## CITY OF PORTLAND

January 3, 2003

Re: 43 Meridian St.  
CBL: 085-D-003

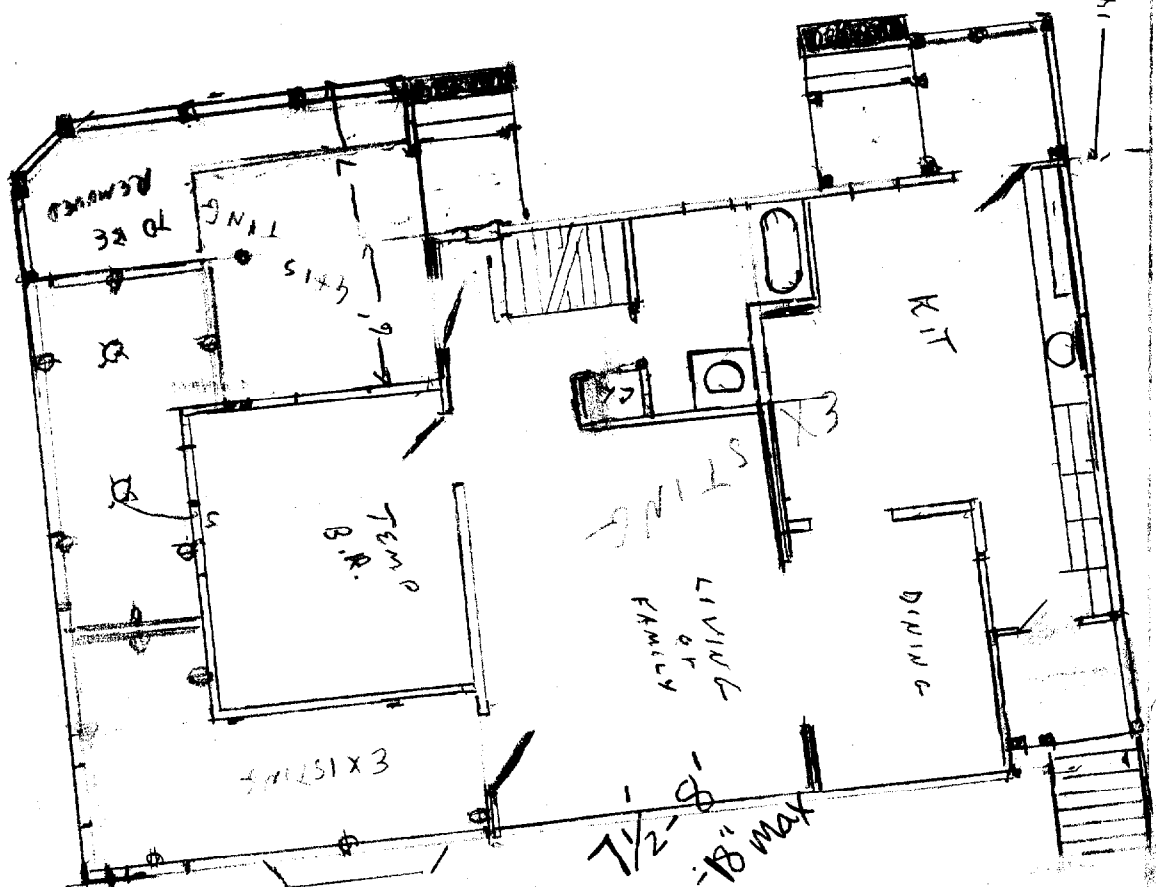
The City of Portland is issuing Building Permit # 02-1047 for your property at 43 Meridian St. During the review process, it came to our attention that some structures had been added to the property without benefit of approvals. Specifically, there are 3 decks that are located near the front & rear exit stairs that total 158 sq. ft. In the IR-2 zone, the City Ordinance allows a lot coverage of 20%. The existing house is legally non-conforming as to lot coverage, not including the decks.

This permit reflects that you intend to remove part of the front right deck. This letter serves as notification that in order to be in compliance with city ordinance and allowable lot coverage, all three decks need to be removed. It is your responsibility to notify this office for inspection when the property is in compliance.
